Objection to NWRL EIS2 Cherrybrook Station proposals

Application No. SSI - 5414

Resident Submission
Jacqui Goddard
11A Robert Road
Cherrybrook NSW 2126

Figure 6.12 Cherrybrook Station - Indicative vehicle and pedestrian movements

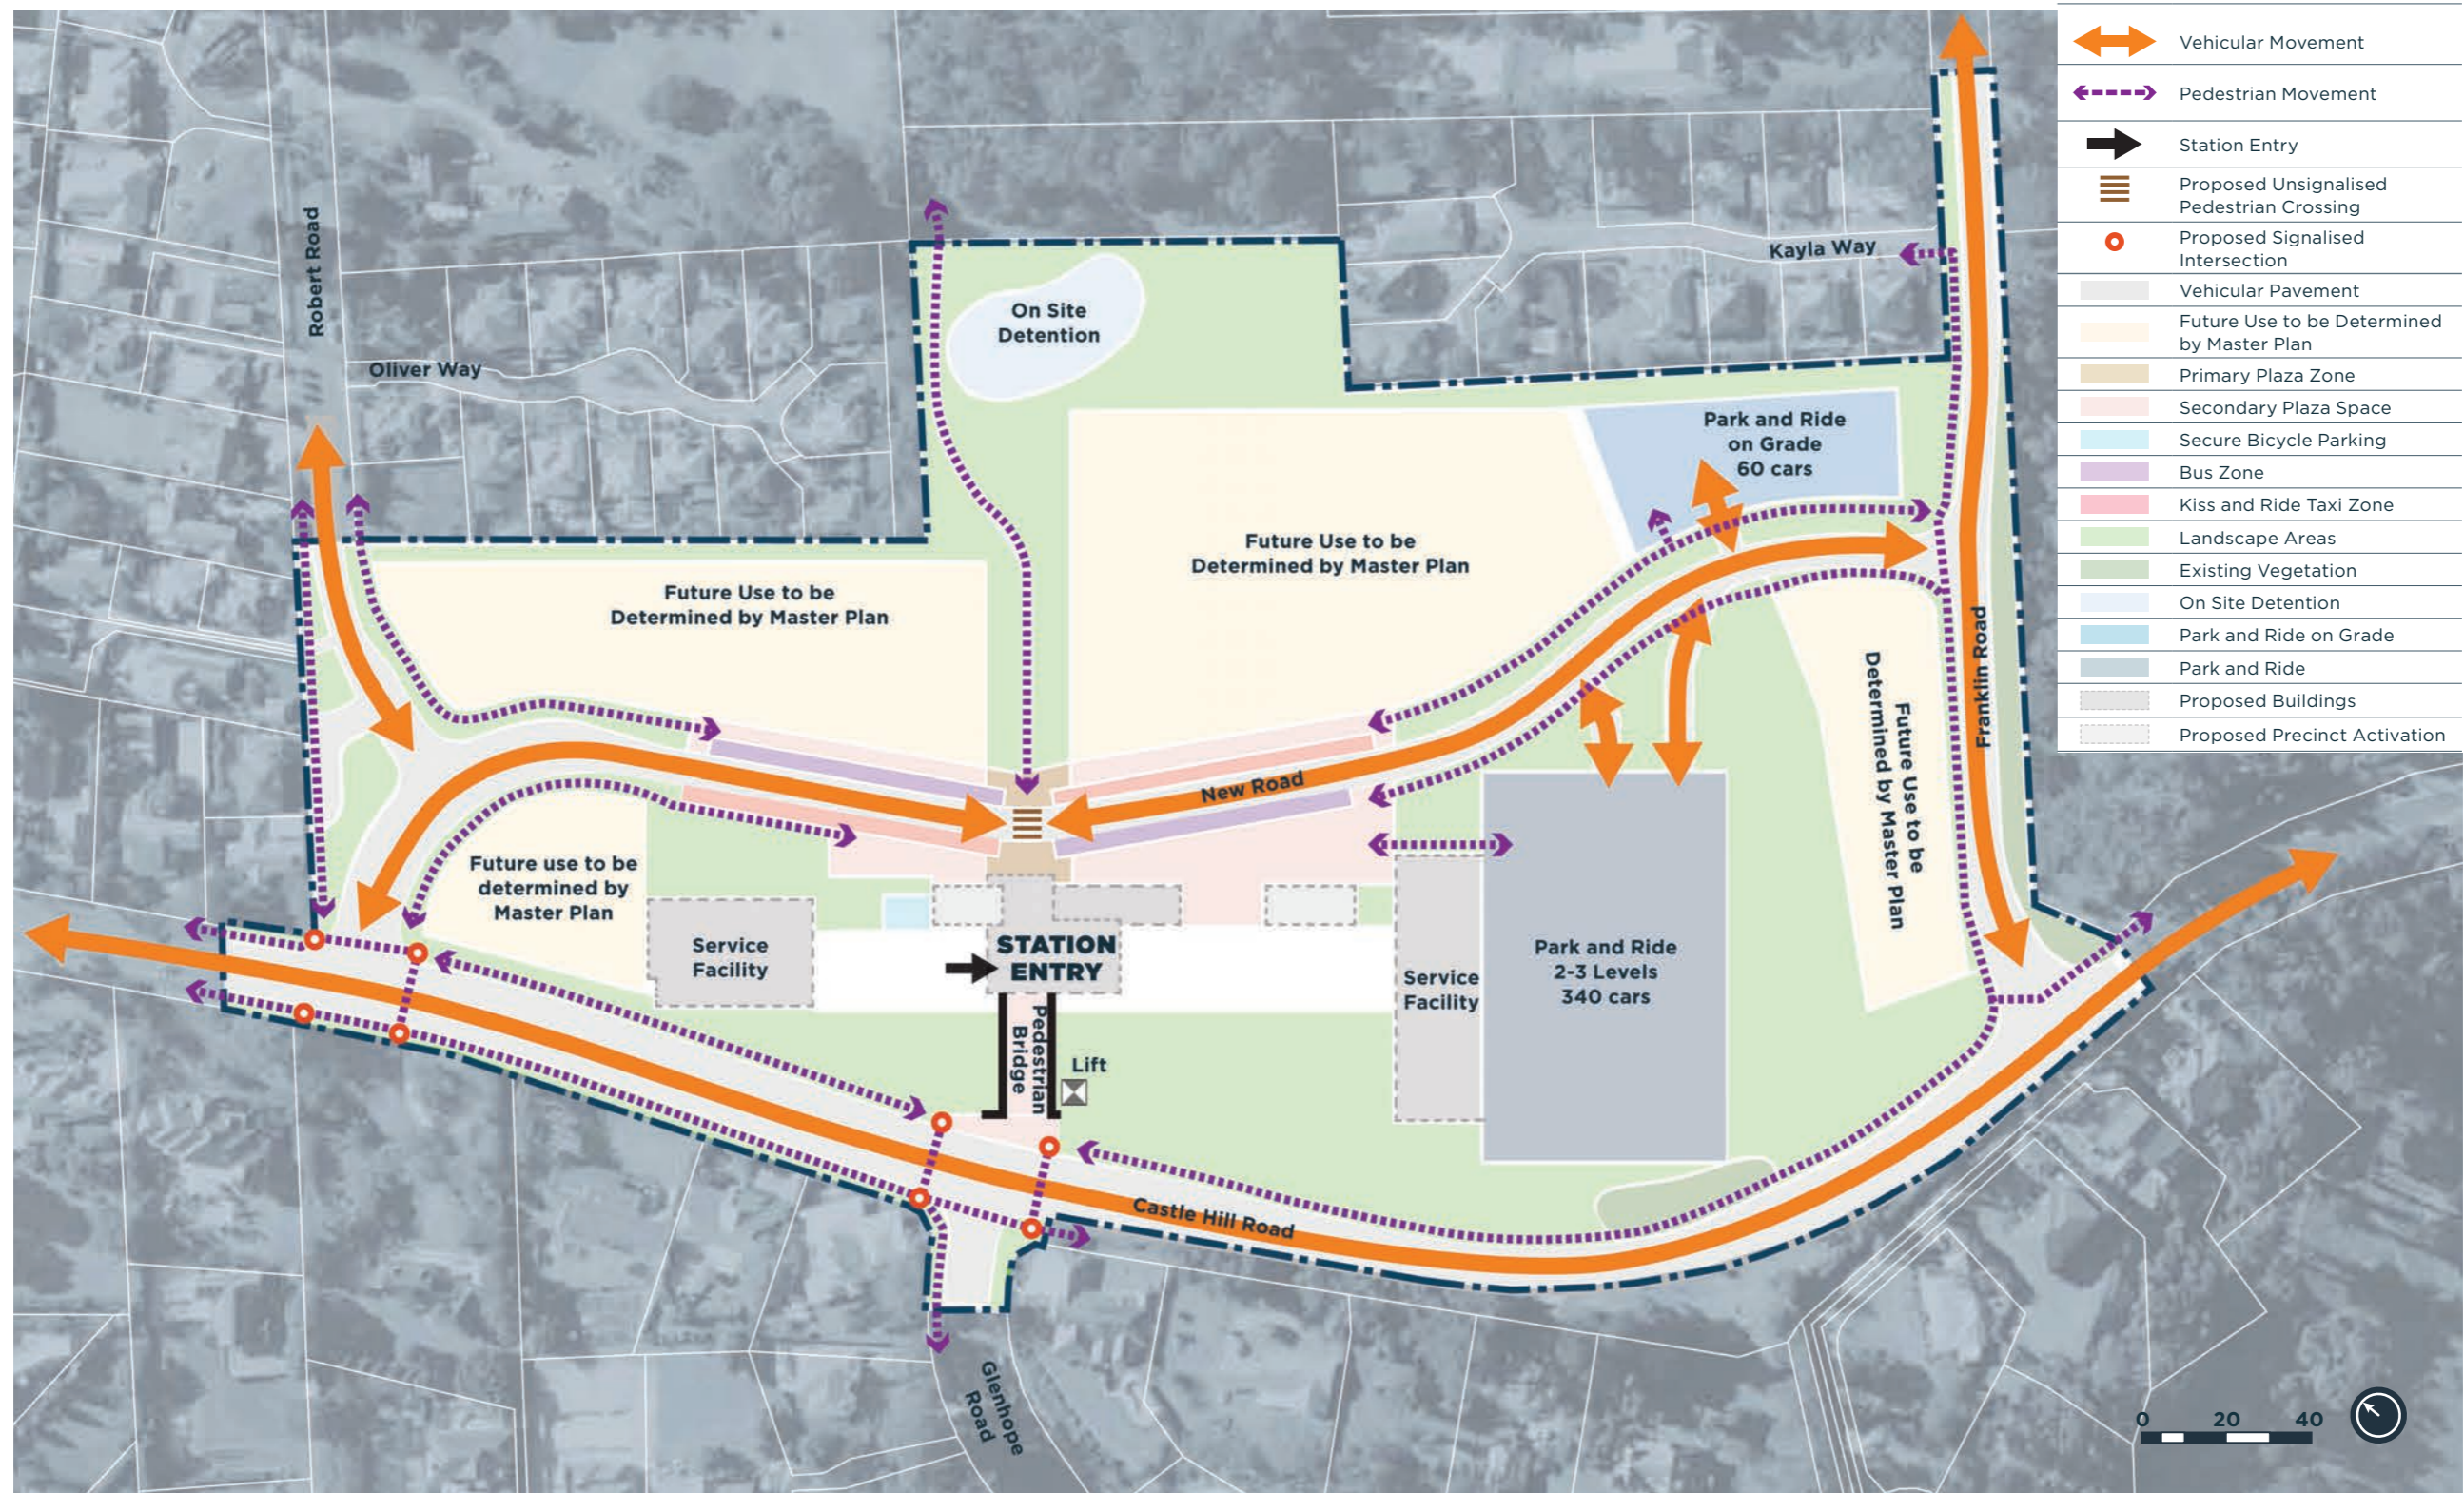
The NWRL proposed access & egress diagram (Fig 6.12 page 6-26) which appears to show traffic being diverted away from the main roads is misleading. When you look at the neighbouring streets it becomes clear that traffic is simply being channelled to other sections of the existing main roads as there are virtually no through roads in this neighbourhood. Technical Paper 2 suggests a traffic increase of 150% in local access streets which is in effect an increase in main road traffic making the other statistics quoted unreliable.
